Subject	2-32 SMITH STREET, SUMMER HILL, PROJECT APPLICATION
File Ref	FM APRIL 2013
Prepared by	Con Colot - Senior Strategic Planner & Projects
Reasons	Provide the Department of Planning & Infrastructure with comments on the Project Application for Stage 1 at the Flour Mills site, 2-32 Smith Street Summer Hill.
Objective	For Council to determine its response to the project plan application.

1.0 Purpose of Report

FIGURE 3
100Y ARI DESIGN FLOOD EVENT
EXISTING CASE - PEAK DEPTHS AND CONTOURS

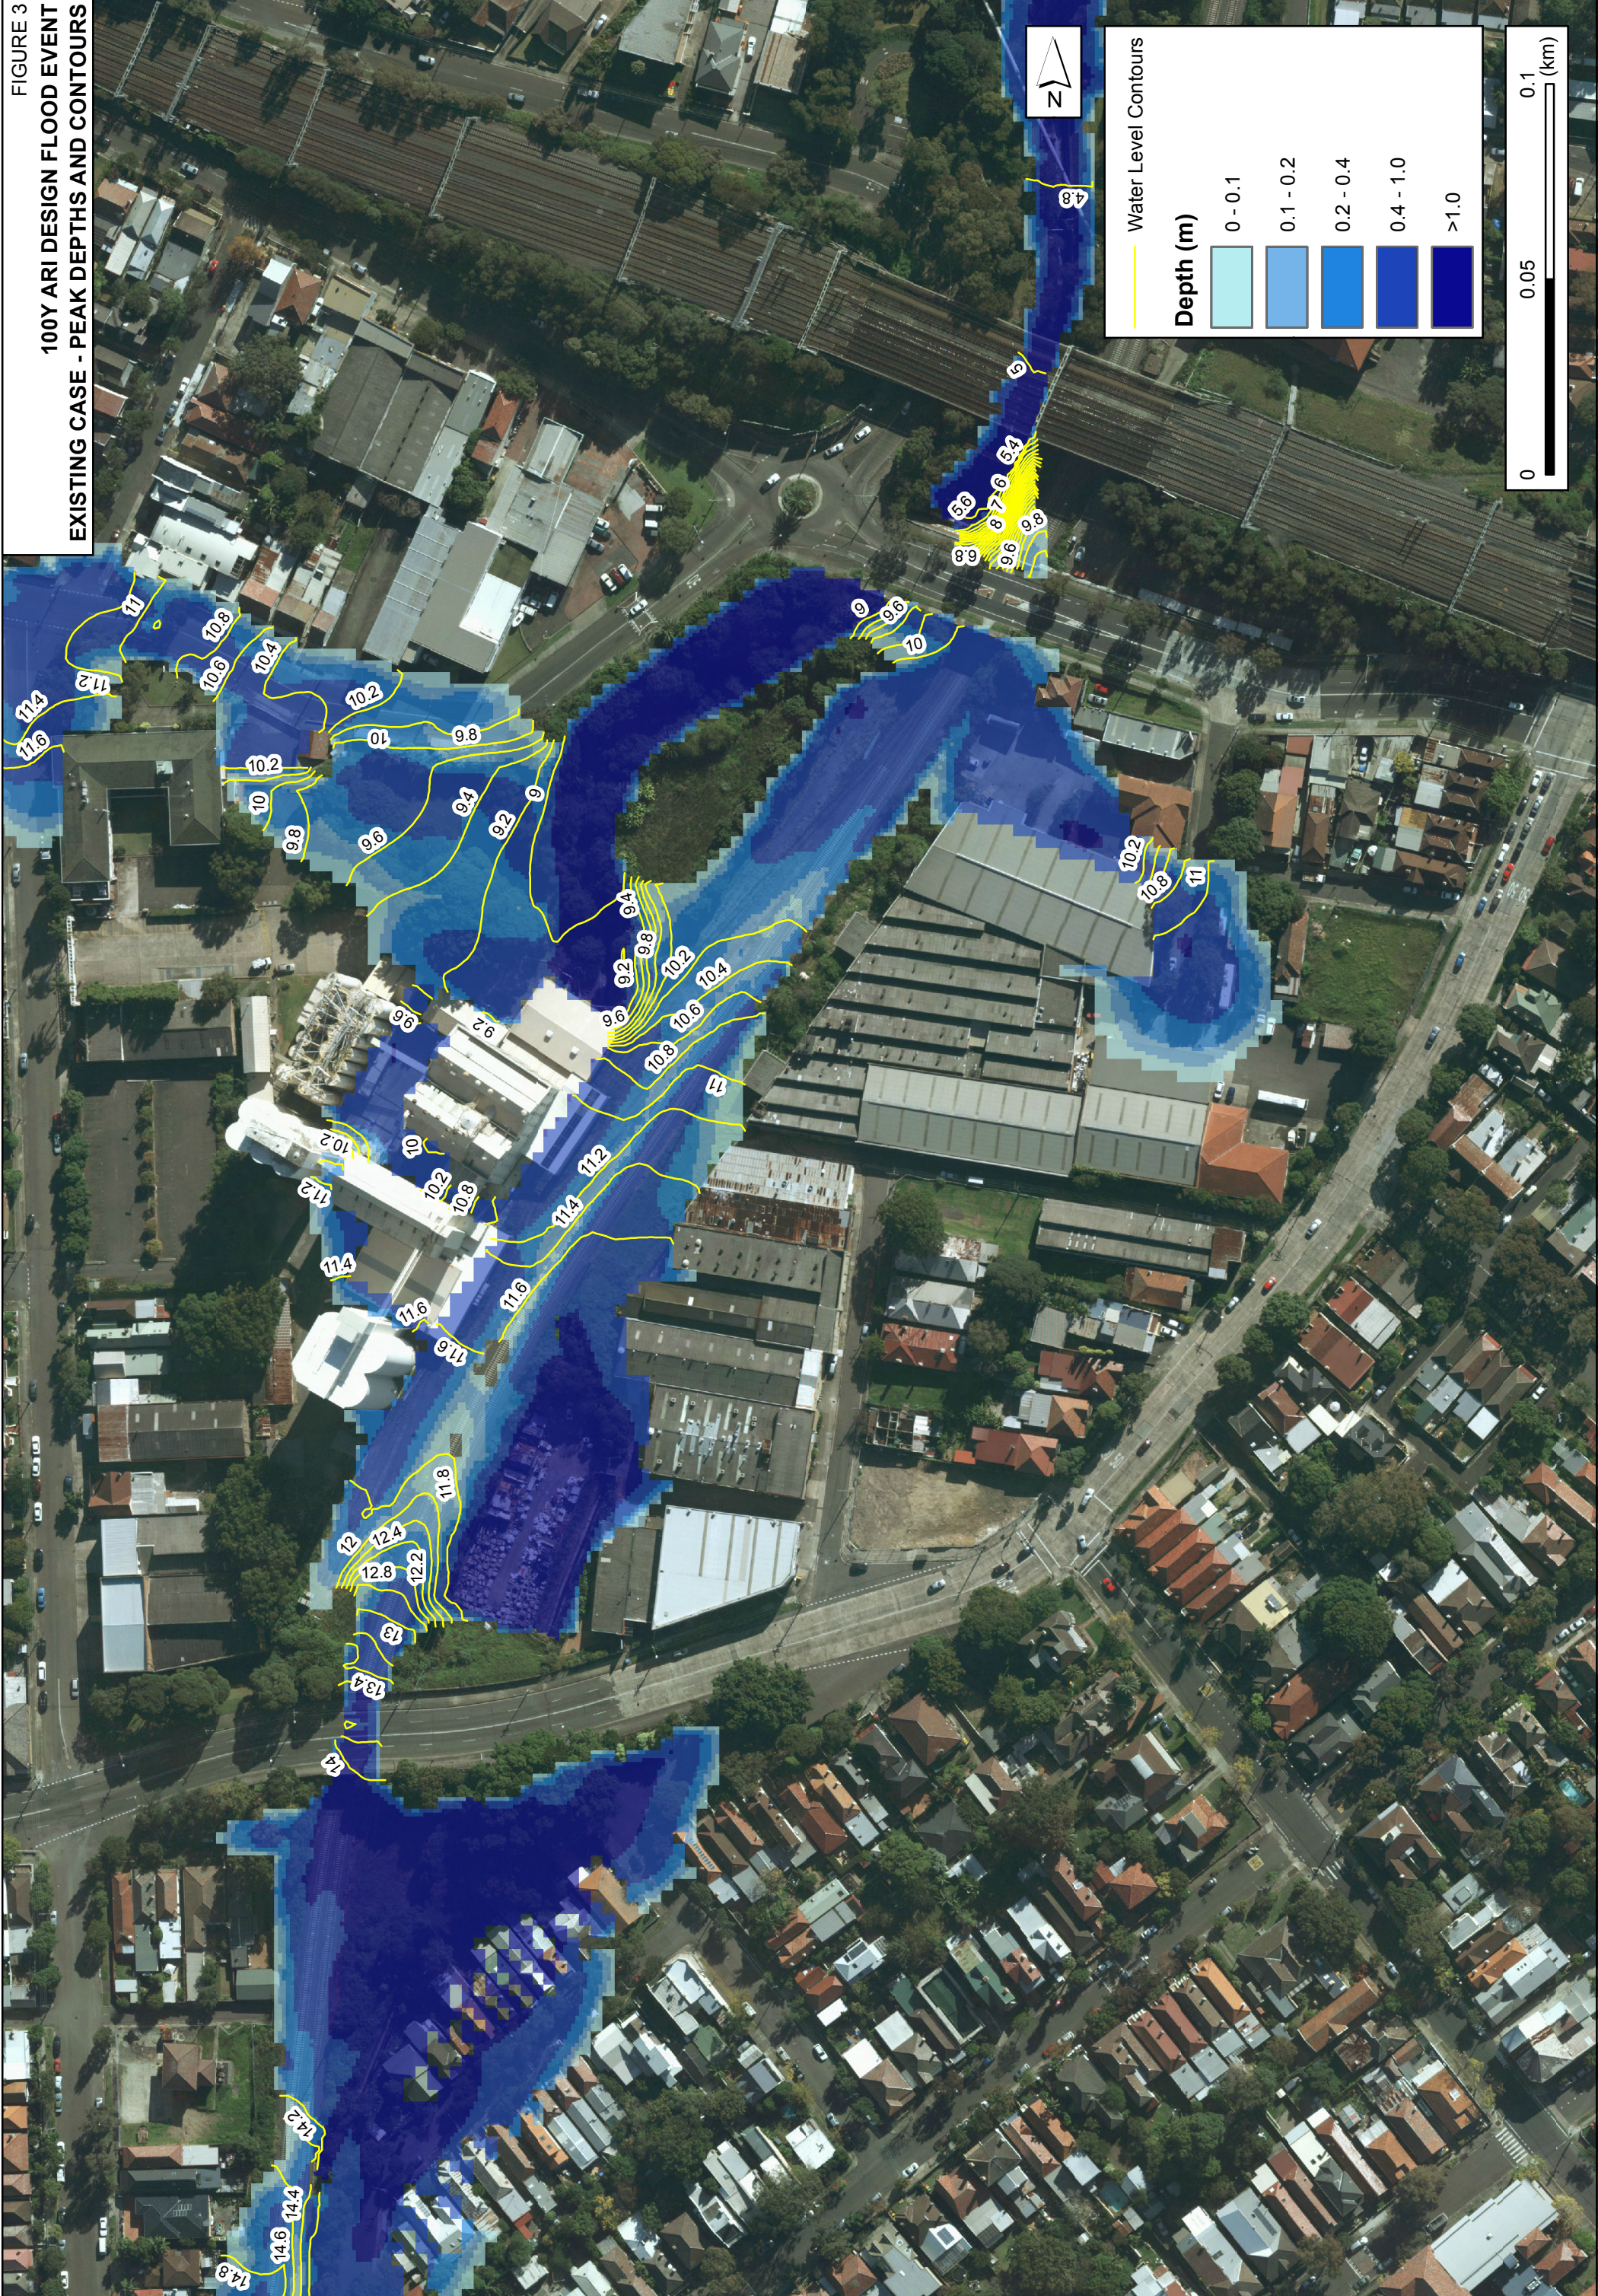
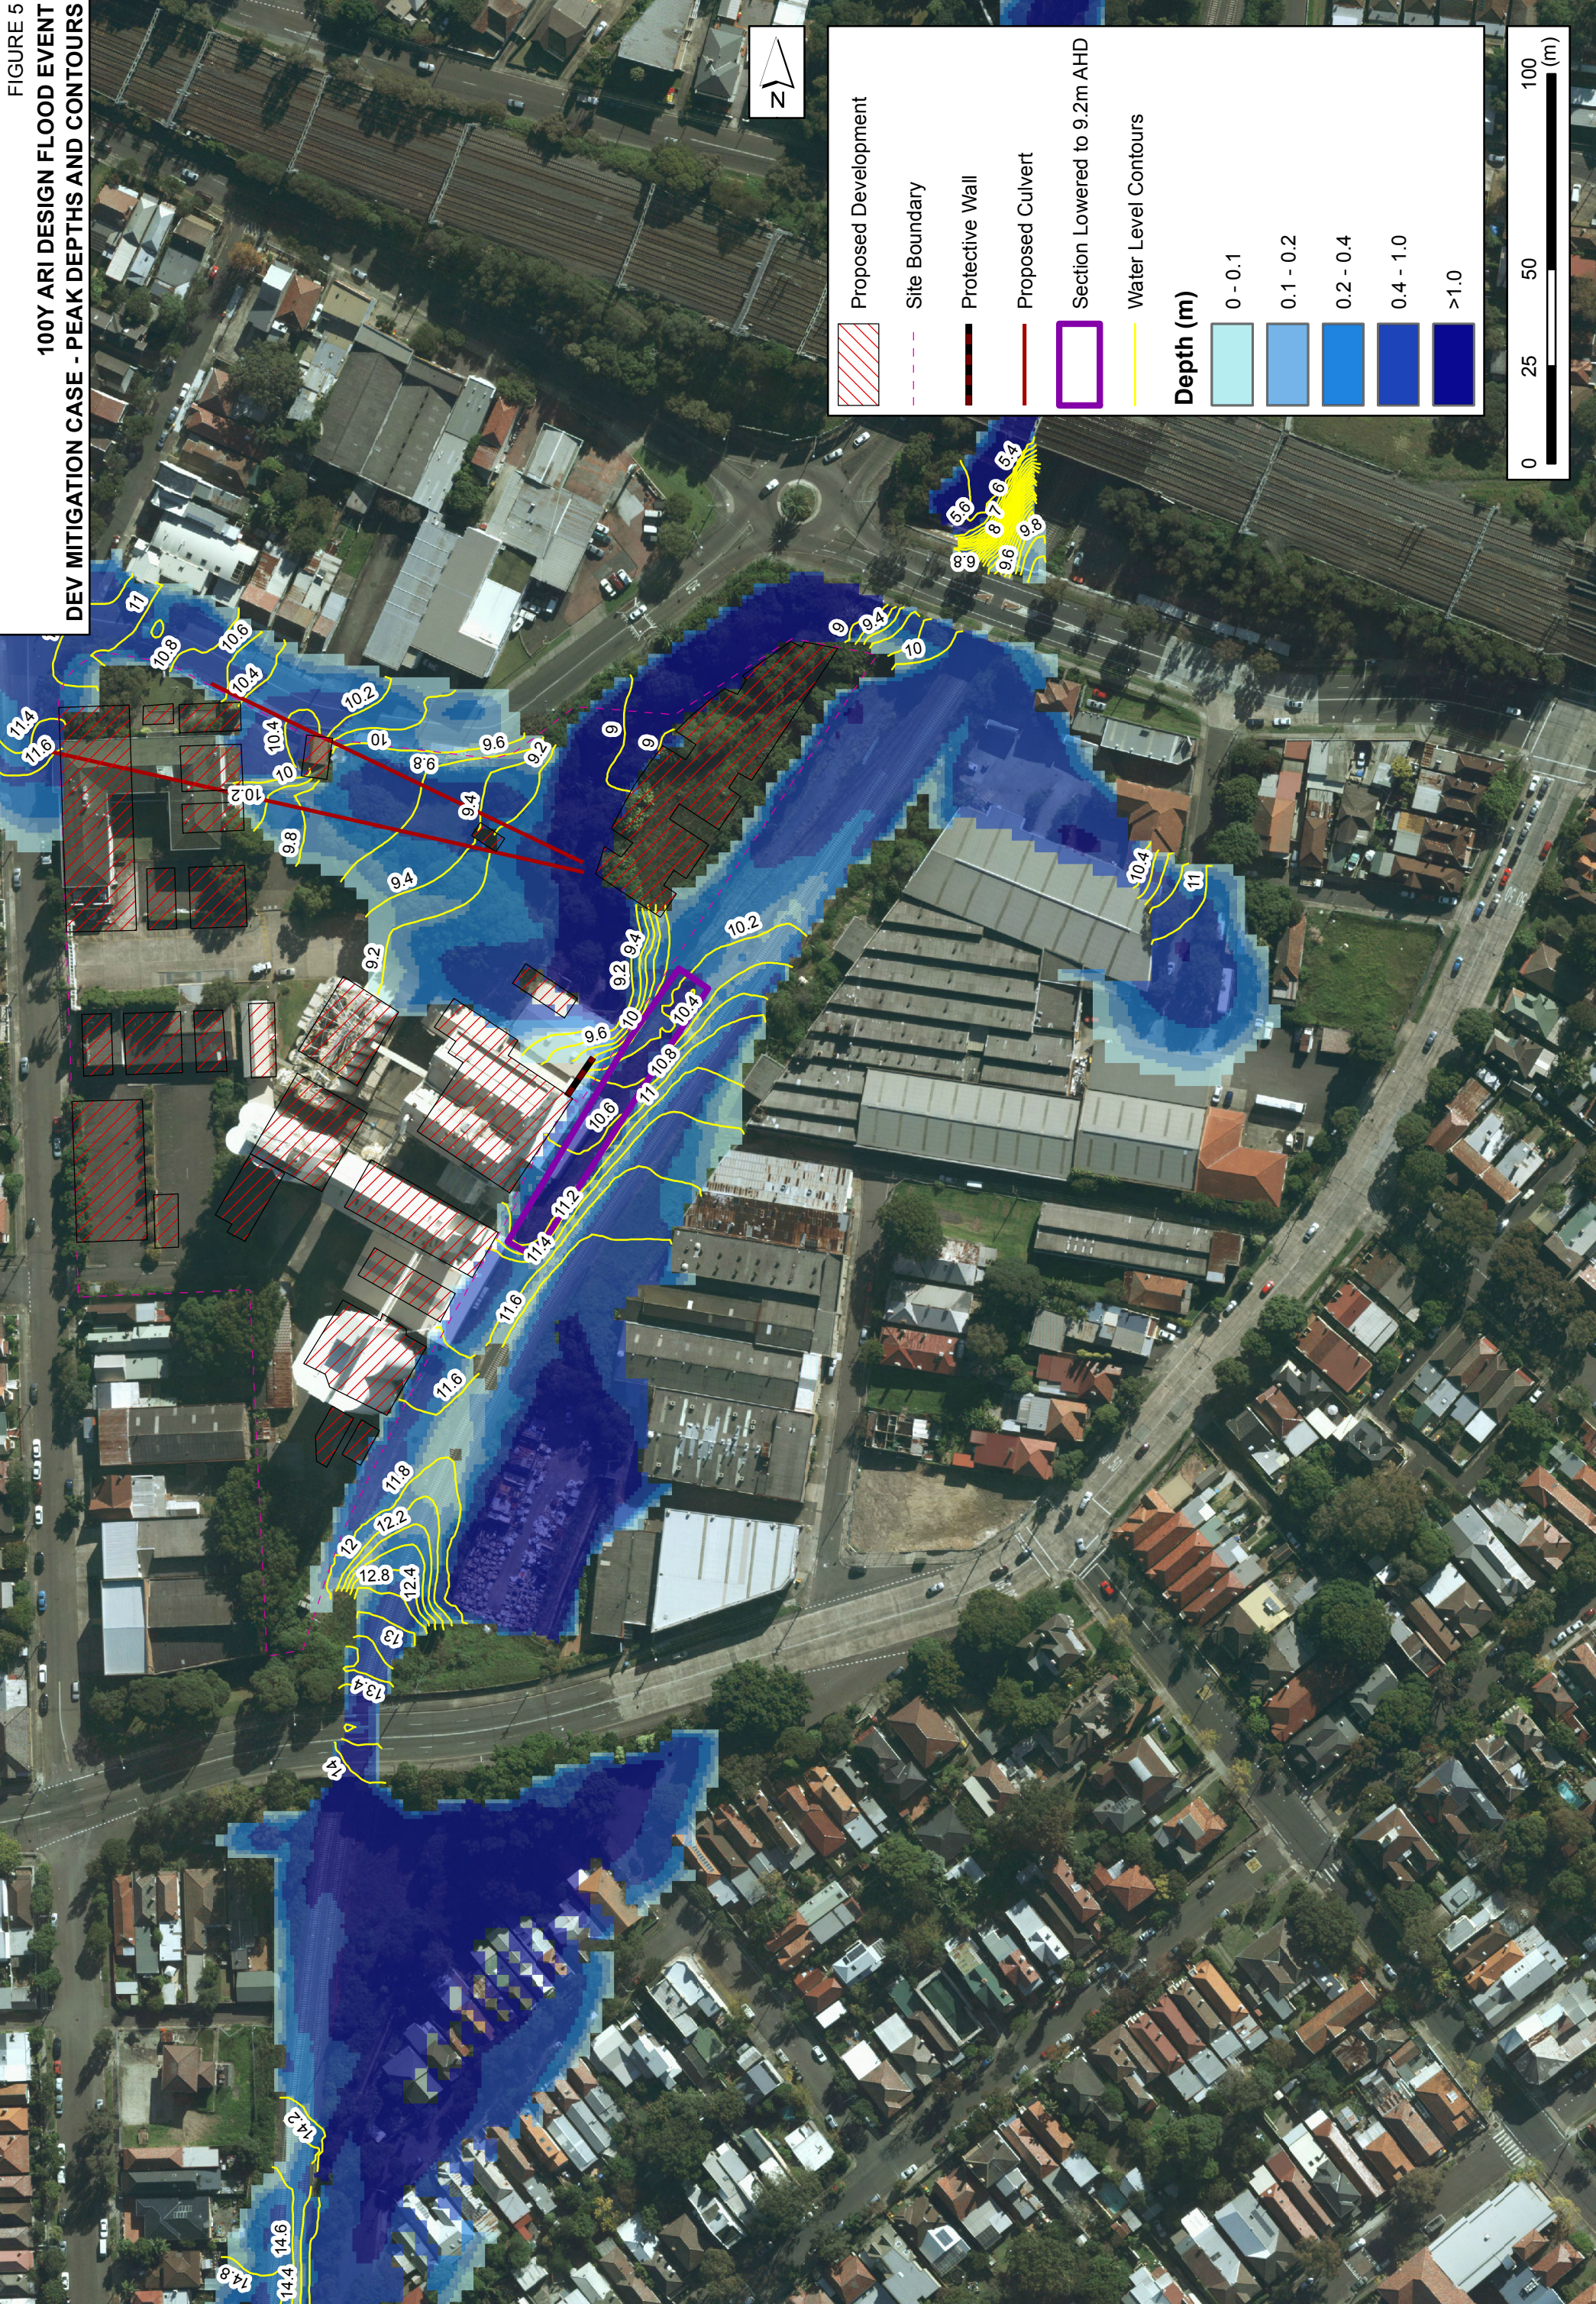
There is a large stormwater catchment area which flows down Smith Street and some of this flow is picked up by a large underground pipe from the Flour Mills site to the Hawthorne Canal - **see Diagram 3** of this report.

Some local stormwater which flows down Smith Street will be diverted around the Stage 1 site potentially down the access pathway link or within the 'Portion 4' allotment. There are various underground pipes (culverts) proposed to deal with this flow.

Council's engineers advise it is not possible at this point in time to determine whether the proposed stormwater disposal system is adequate based on the submitted documentation. Consultation between Ashfield Council would be required with Sydney Water on this matter. Additional engineering staff resources, or an independent review by consultants, would be required to analyse and check the various and numerous complexities associated with the proposed stormwater mitigation work, given the large upstream area catchment which might otherwise be adversely affected. Easements would also need to be placed on the site, which would affect the proposed subdivision plan.
